KITTITAS COUNTY COMMUNITY DEVELOPMENT SERVICES

Subject: Shoreline Exemption Permit (SX-24-00001 Baumann) – Deemed Incomplete – Request for Additional Information

UNIFIED SITE PLAN
TAX PARCEL NUMBER 615133
10350 MANASTASH ROAD, ELLENSBURG
 FOR
WILL BAUMANN
 KITTITAS COUNTY

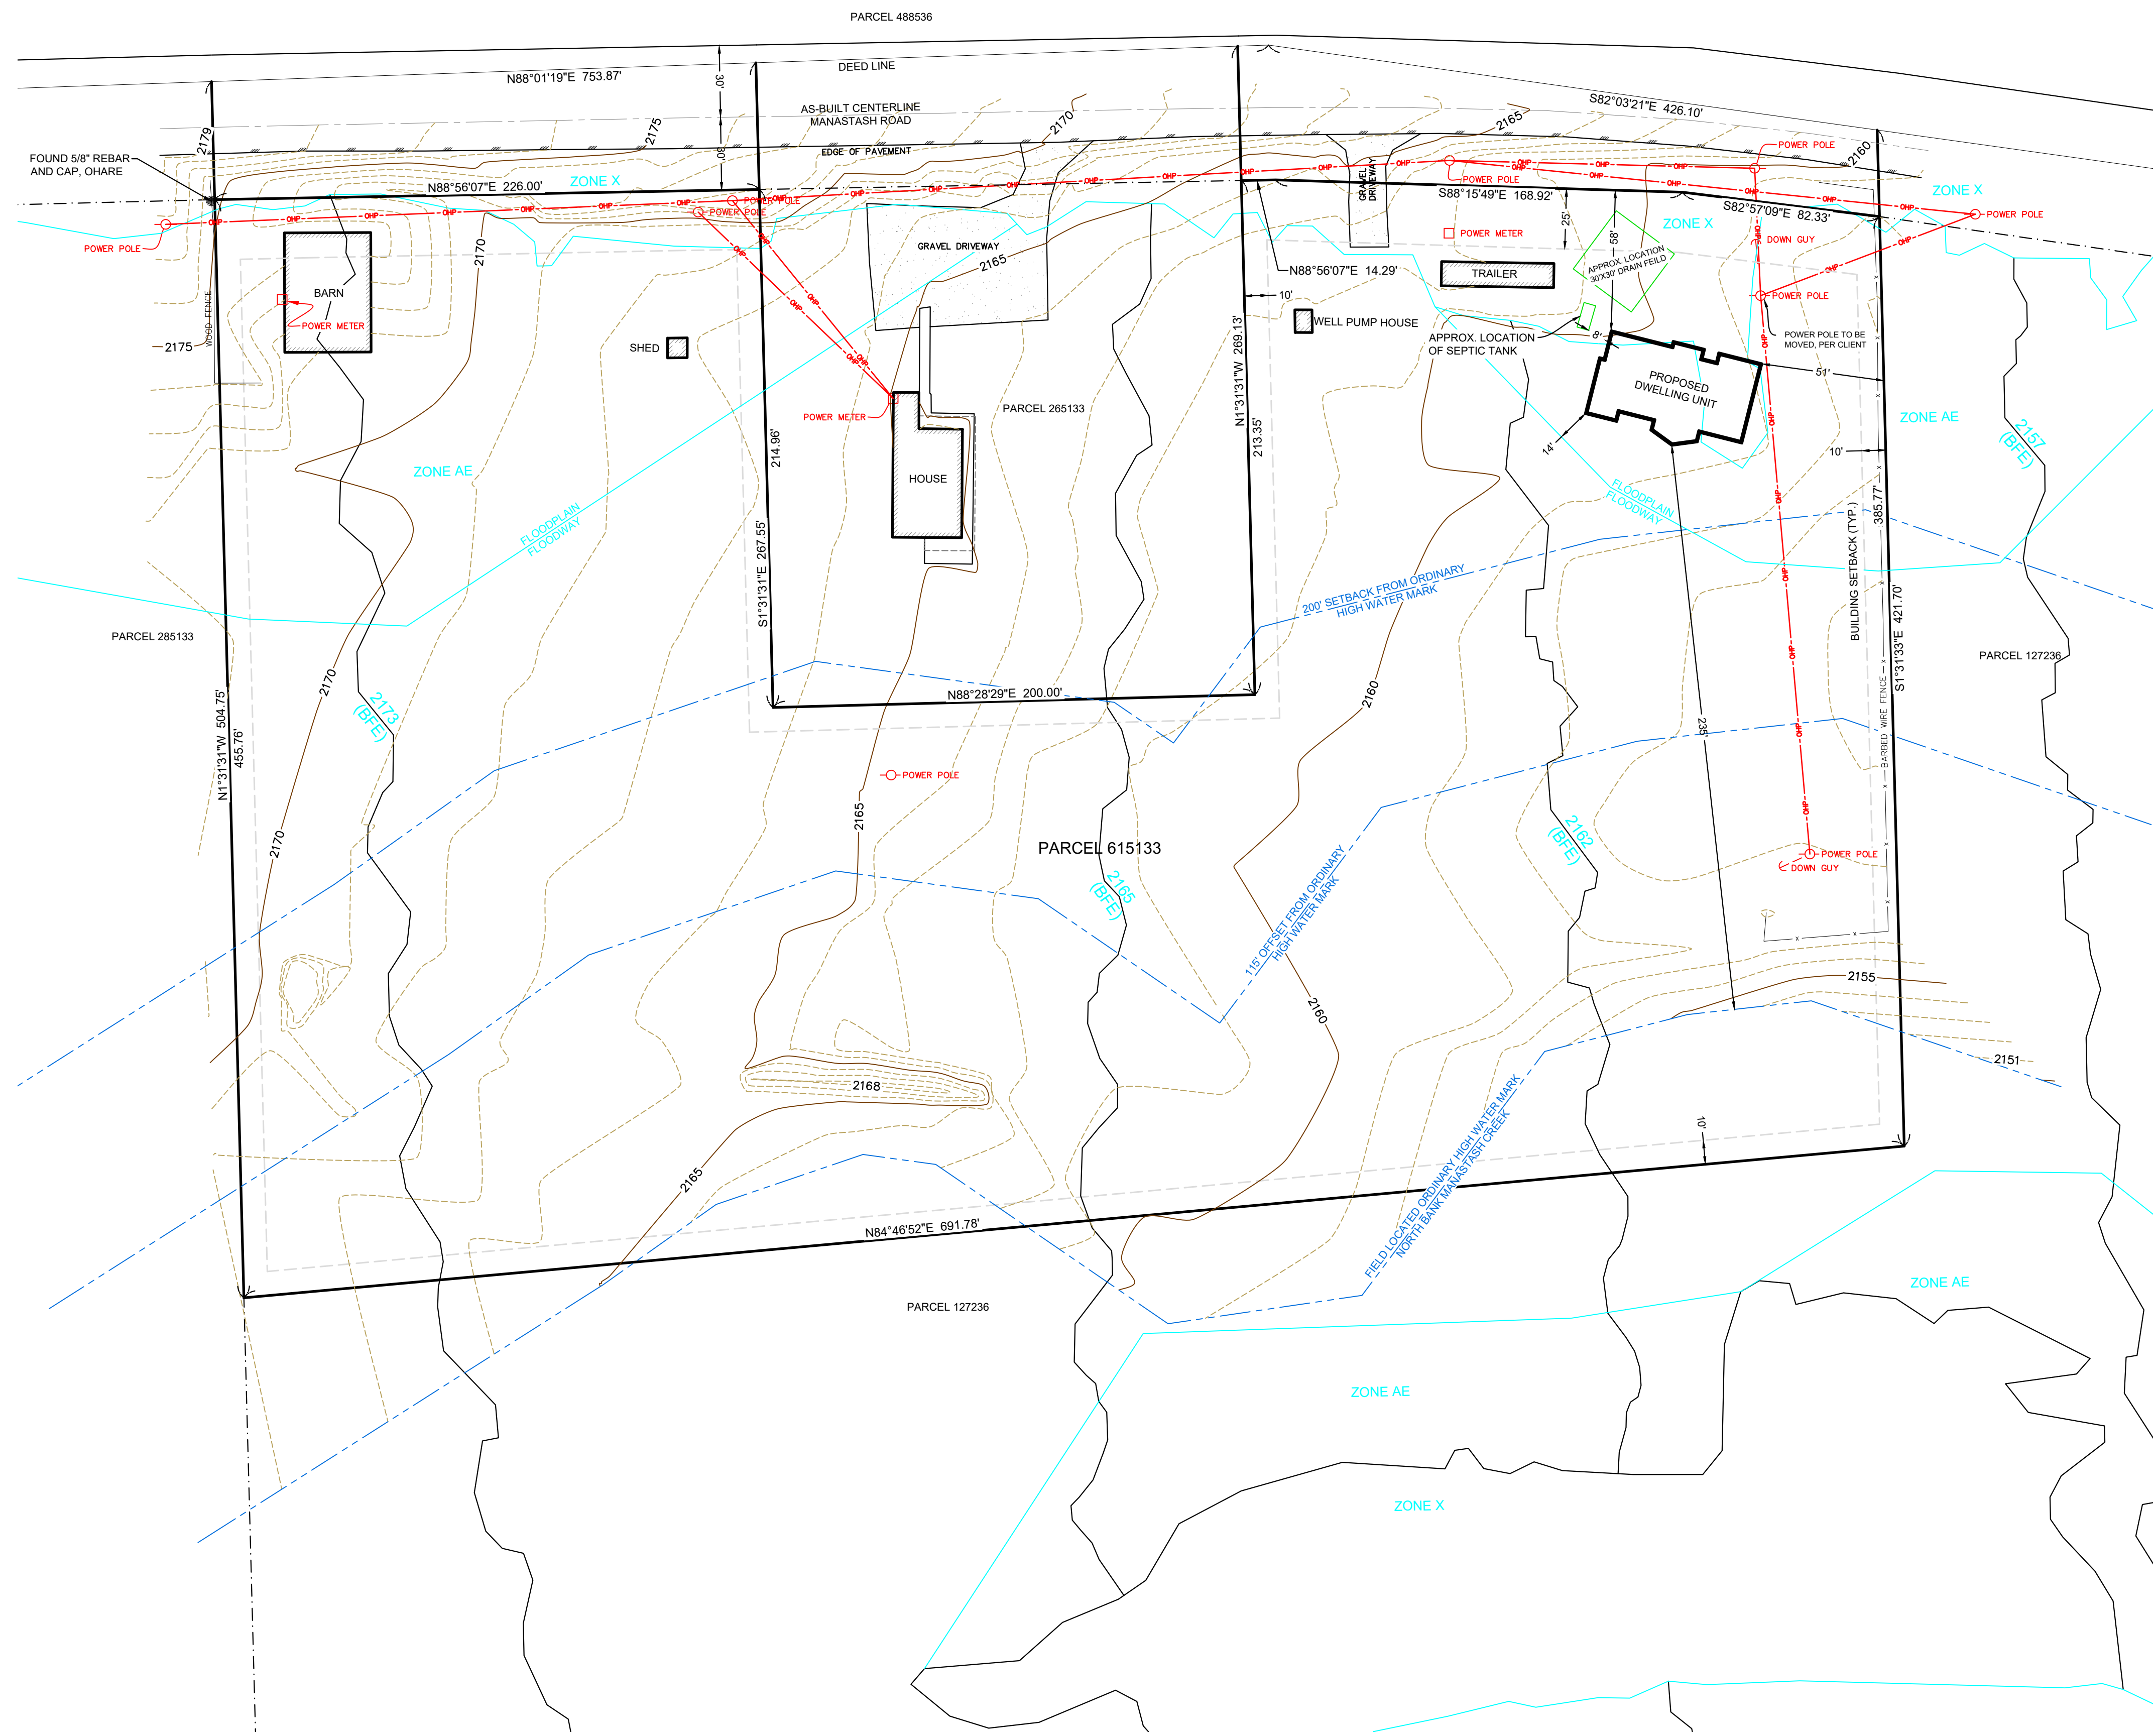
1. Please provide the locations of the well and septic facilities on the site plan.
2. Please provide the proposed uses (all new structures) and their dimensions. Please also provide each structure's distances from property lines, rivers, and horizontal distances from the Ordinary High Water Mark (OHWM).
